Re Development at Root Farm, Dunsop Bridge
planning approval ref: 3/2021/0952

Please find enclosed on behalf of our client, The Duchy of Lancaster, a variation of condition planning application in respect to the original planning approval ref 3/2021/0952 for the redevelopment of Root Farm, Dunsop Bridge.

Enc Application form
 KL2887 / 04C (proposed site layout), 05B (proposed plans) and 06B (proposed elevations)
 Updated D&AS
 Application fee

**PROPOSED SITE LAYOUT**

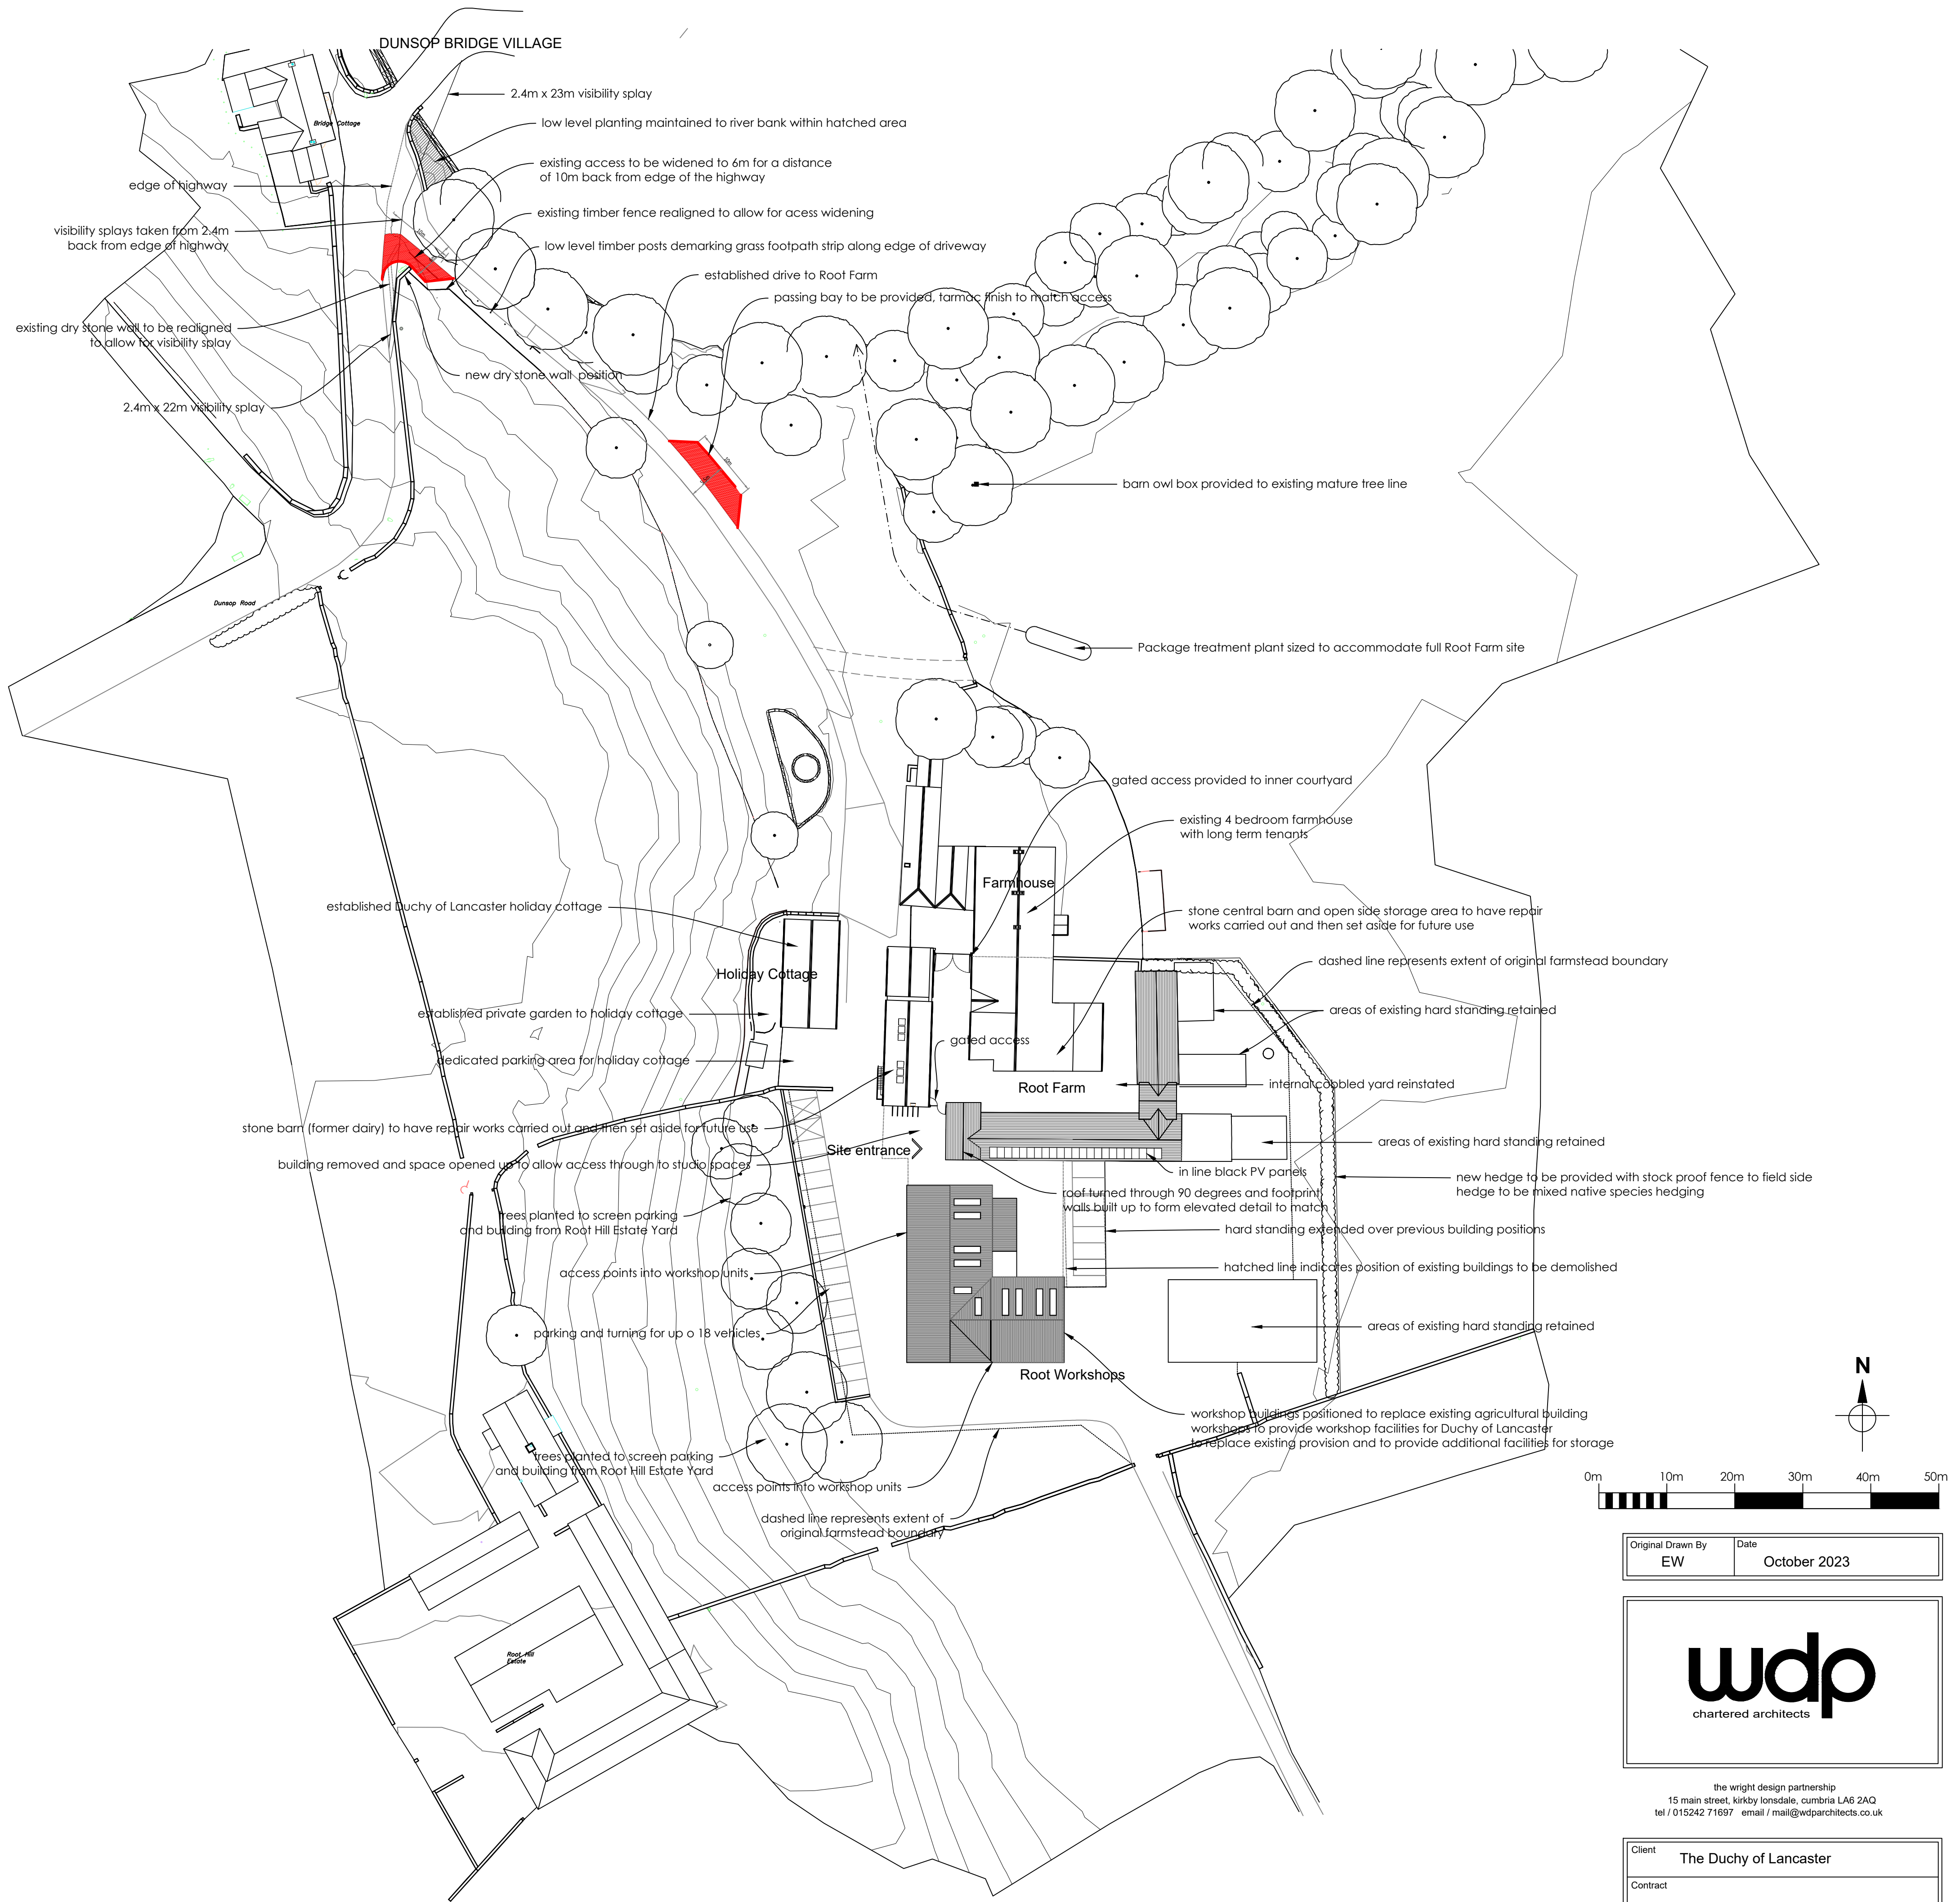
- The existing concrete buttresses to the west elevation of the dairy building are to be removed and a new external stone staircase positioned to access the existing first floor door position.
- The new build workshop units shown with stone facing to the previous exposed blockwork detail.
- The new build workshop units have had separate pedestrian doors added for ease of access without opening/closing approved sliding timber doors and roller shutter detail.
- The rooflights to the new build workshop units have been adjusted in their position but all remain on the east / north roof slopes as agreed previously.
- The bin store to the new build workshop units is proposed as open with no roof covering.
